Engineers Comments Regarding Surface Water Drainage

Application Reference:	AL/13/25/DOC	Reviewer Reference:	ADC/EXT2/D2134/70
Planning Officer:	Hannah Kersley	Date of Review:	27.11.2025
Site Name:	Karenza Hook Lane Aldingbourne PO20 3TB		
Application Description:	Approval of details reserved by condition imposed under reference AL/154/23/PL (APP/C3810/W/23/3335883) relating to condition number 3 - Construction Management Plan, condition number 5 - surface water drainage scheme, condition number 8 - external materials and finishes and condition number 9 - energy.		
Assessment Number:	1 of 2

Response	Condition 5: Objection
-----------------	-------------------------------

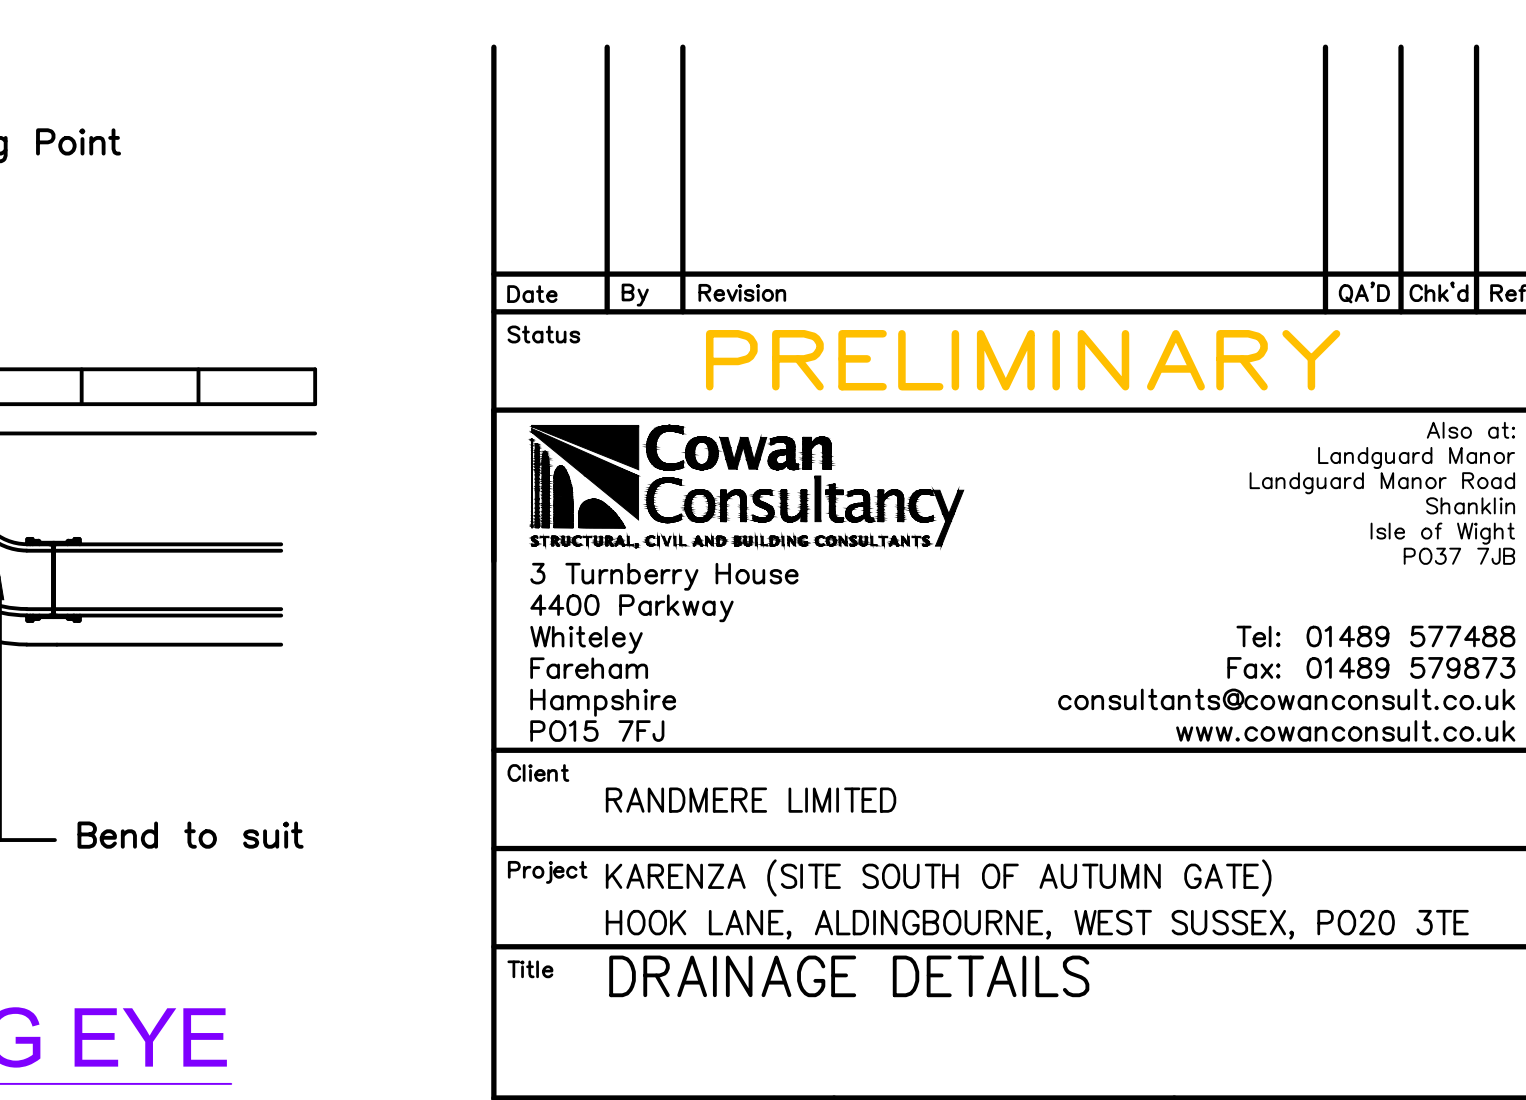
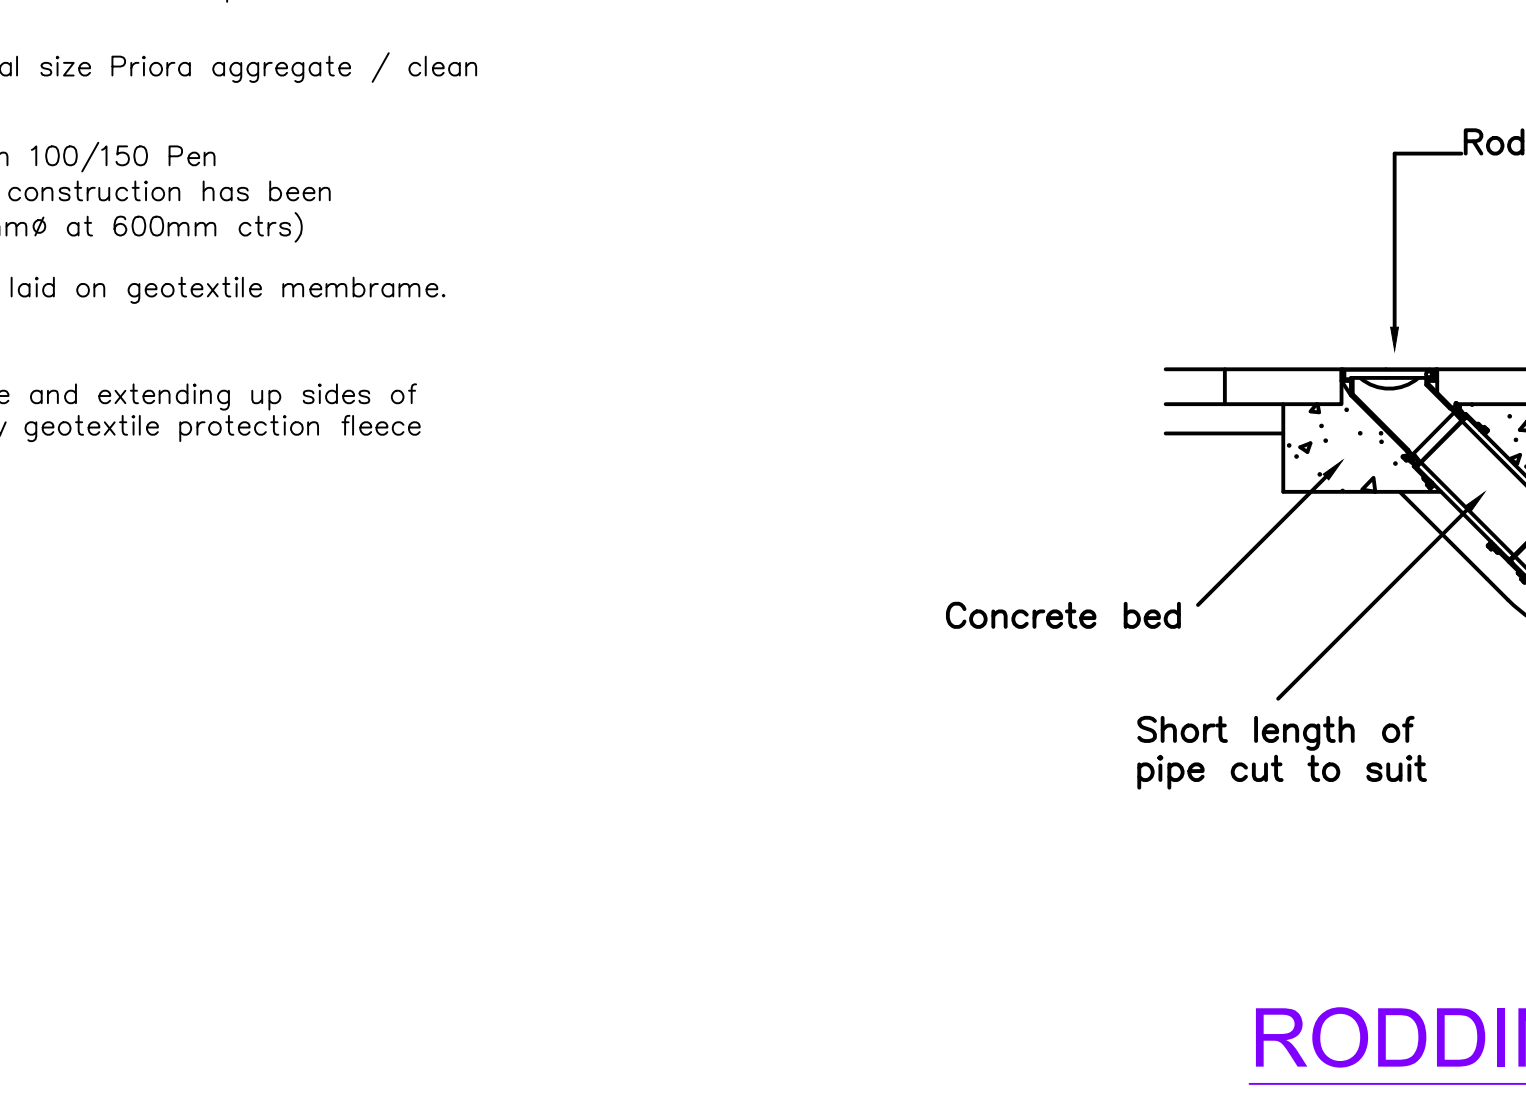
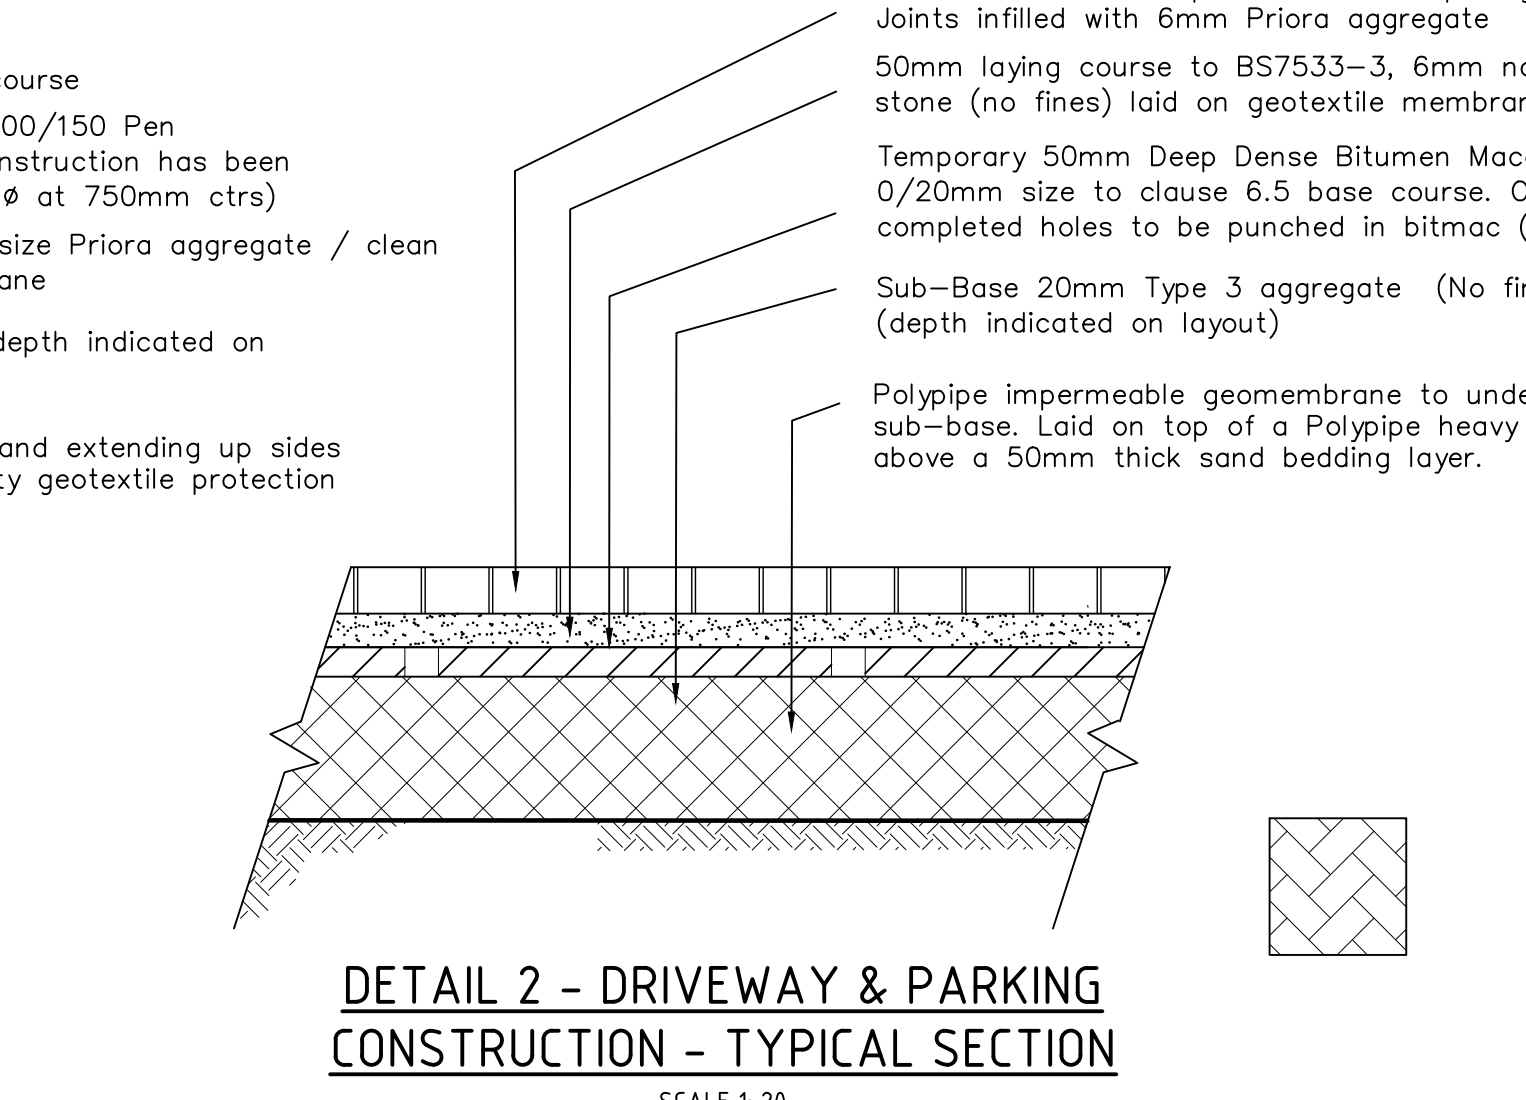
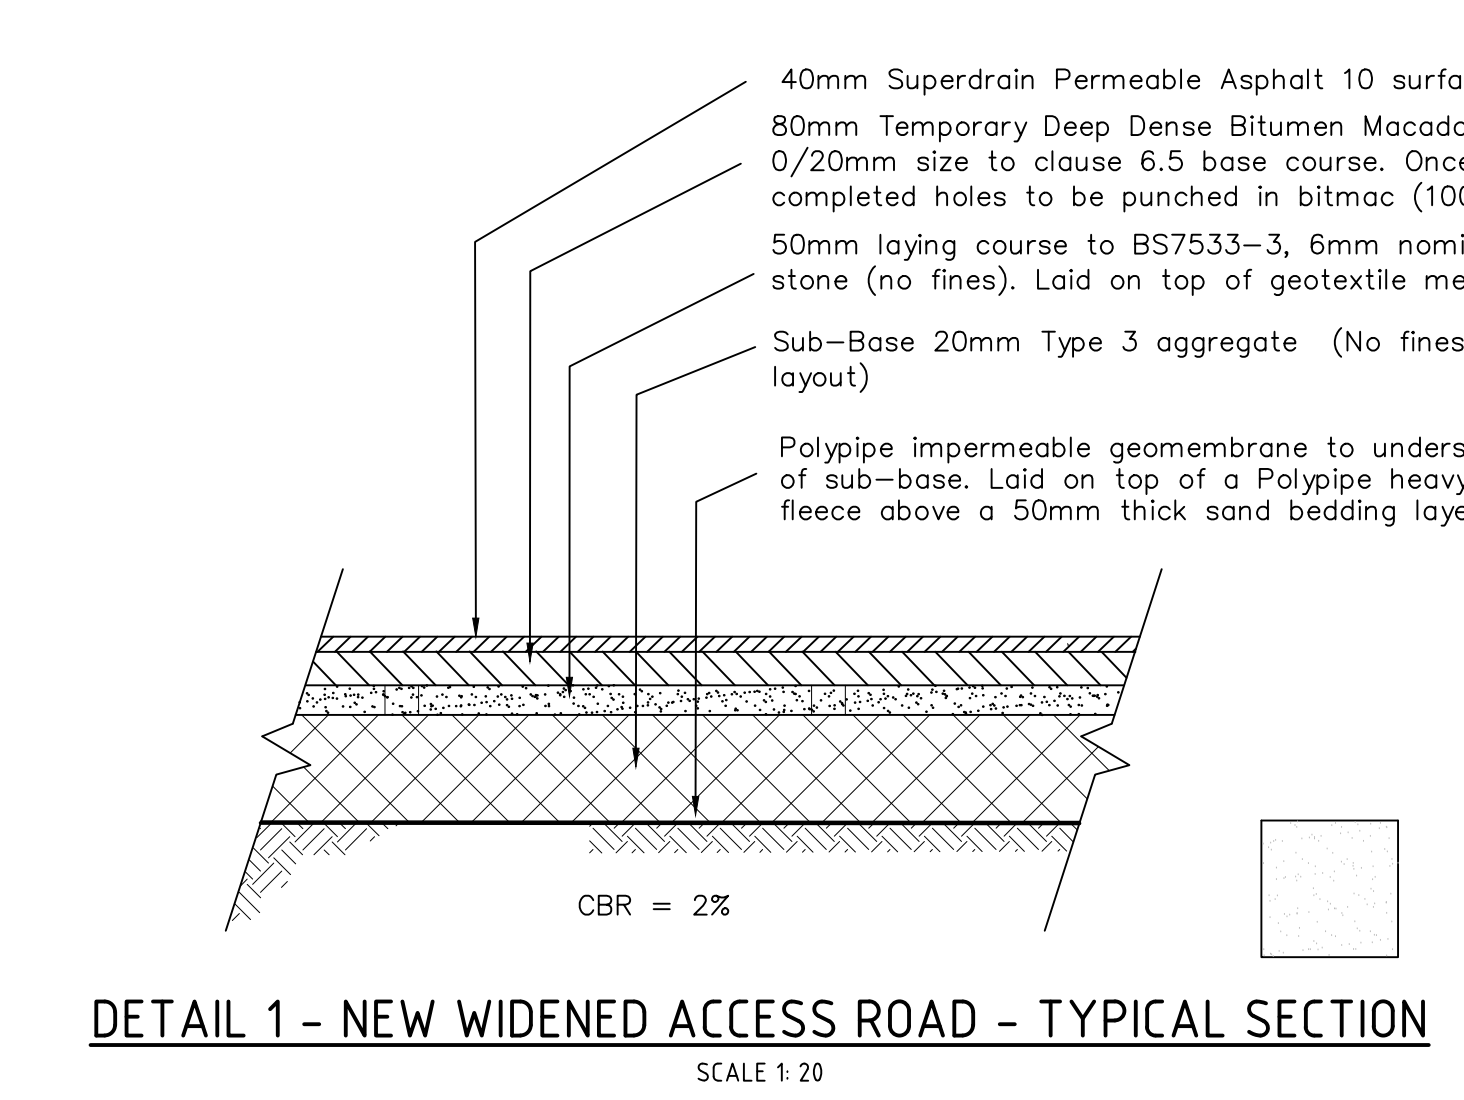
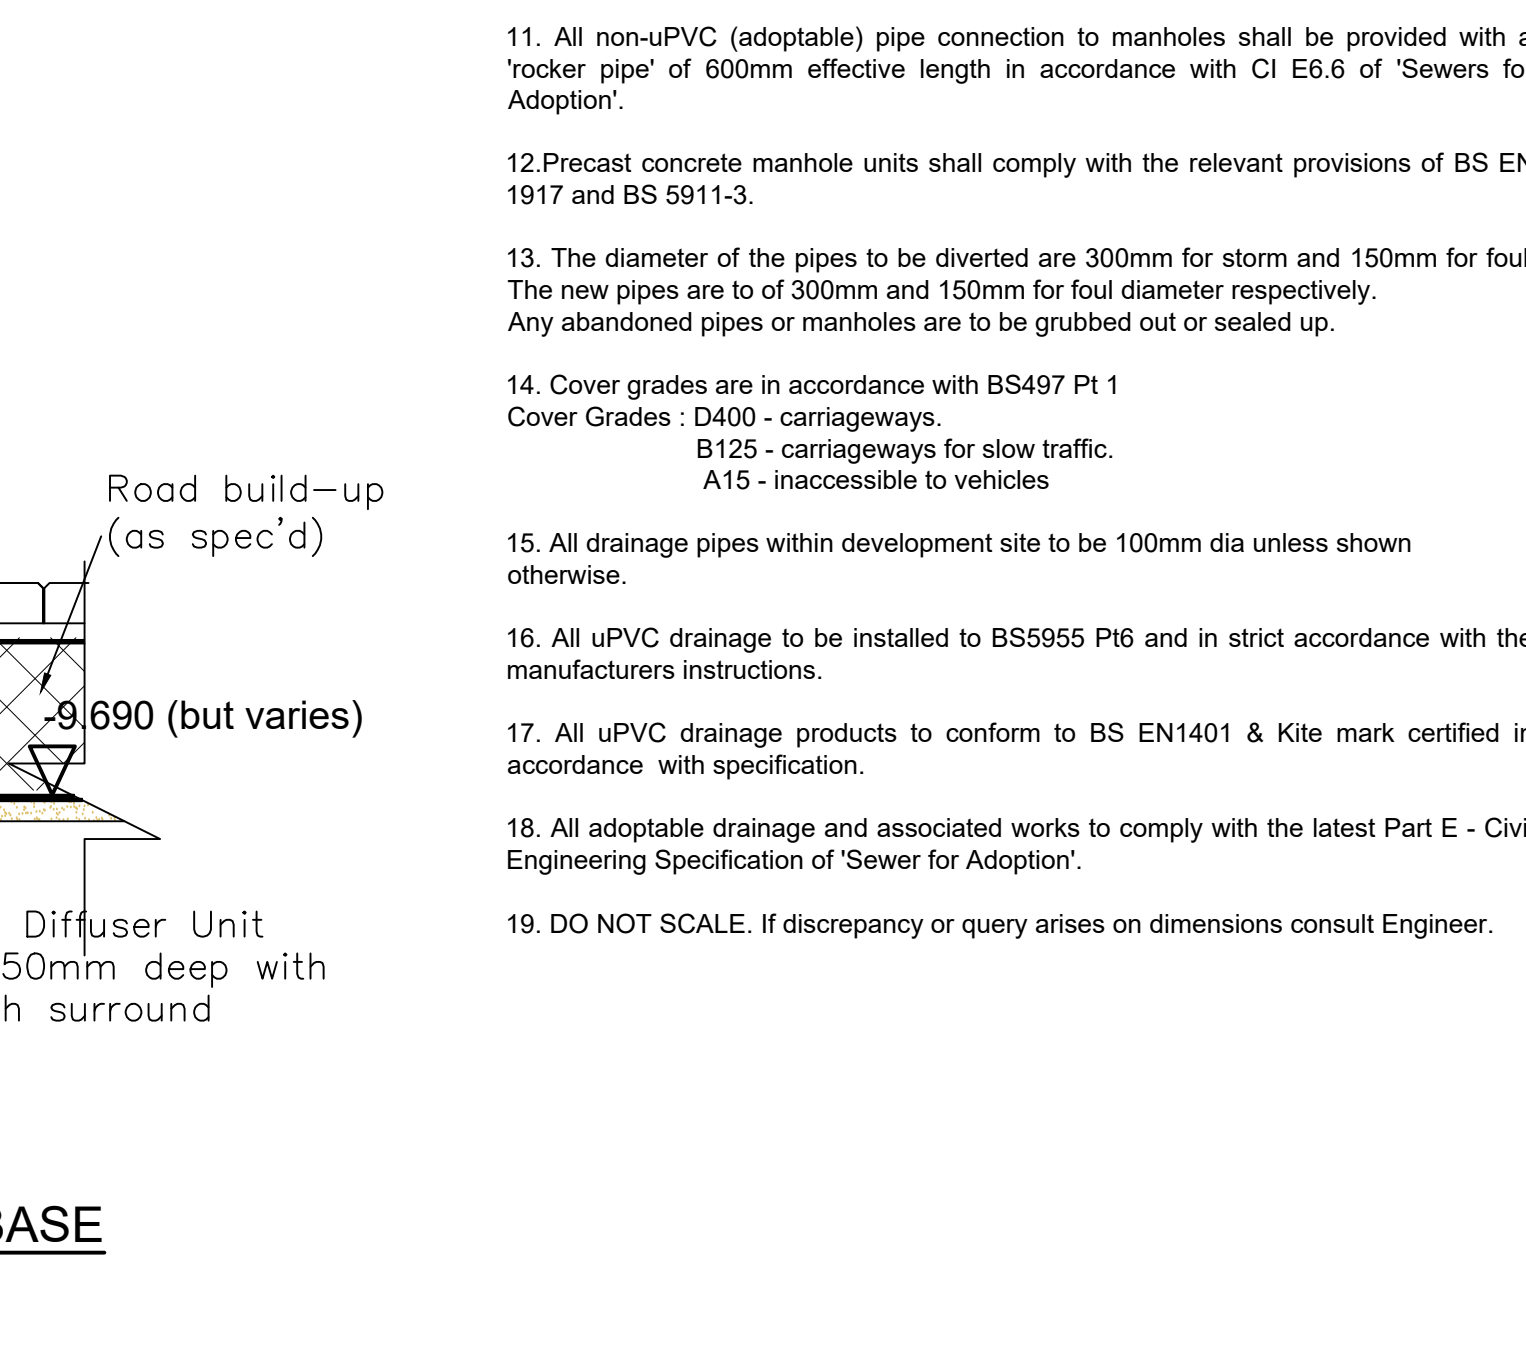
14.	ADC Drainage Comments 29/04/2025 The hydraulic calculations specify node SW-13 as a vortex flow control with an invert of 9.49m, however drawing 435050-221P2 shows this to be higher @ 9.494m. As cited above, for certainty the as-built levels must be used as they may not correlate with the phase 1 design. Designer Response 25/06/2025 Amended in the model	To clarify this is now SW-14 in the revised calcs with the correct invert. Comment closed.	OK		
15.	ADC Drainage Comments 29/04/2025 The hydraulic calculations specify several nodes as 700mm diameter which is not a recognised manhole/IC chamber size. Designer Response 25/06/2025 Updated to as built 450mm dia	S11, S12,S13,S14 are noted to be 500mm control chambers. Comment closed.	OK		
16.	ADC Drainage Comments 29/04/2025	Comment closed.	OK

18.	ADC Drainage Comments 29/04/2025 The cover level and invert levels for numerous nodes do not appear to correlate wholly with drawing 435050-221P2. Designer Response 25/06/2025 updated	Comment closed.	OK		
19.	ADC Drainage Comments 29/04/2025 Please explain wat is the relevance of a 1:500 return period has been demonstrated, also with CC. Designer Response 25/06/2025 This has been removed	Comment closed.	OK		
20.	ADC Drainage Comments 29/04/2025 Drawing 435050-221P2 is very difficult to review where phase 1 is greyed out and the key does not clarify all items i.e. its is assumed the pink text represents the phase 1 formation levels?	Comment closed.	OK

Designer Response 25/06/2025 The revised drawing is clearer and also the construction issue of phase 1 has now been provided				
21.	ADC Drainage Comments 29/04/2025 Drawing 435050-221P2 requires formation levels at all corners and at outlets/inlets of all permeable pavements. Designer Response 25/06/2025 This has been added	Comment closed.	OK		
22.	ADC Drainage Comments 29/04/2025 Rainwater pipes run through silt traps (catchpits) and into the permavoid. Please provide a construction detail of how this is interfaced. Designer Response 25/06/2025 Detail provided on Drawing 435050-222P	Comment closed.	OK		
23.	ADC Drainage Comments 29/04/2025	Comment closed.	OK

Please provide construction details for all features identified on drawing 435050-221P2. Designer Response 25/06/2025 Detail provided on Drawing 435050-222P				
24.	ADC Drainage Comments 29/04/2025 Measures to protect the permeable pavement (asphalt construction) during the construction period must be annotated on the drawings to ensure that it does not become silt up prior to completion of the project. Designer Response 25/06/2025 See details on drawing 435050-222P	Comment closed.	OK		
25.	ADC Drainage Comments 29/04/2025 Please provide details of the foul drainage routing so this can be reviewed in conjunction with the surface water drainage.	Still missing on drainage GA drawing 221P. Comment outstanding.	Foul added to layout	Noted. Comment closed.
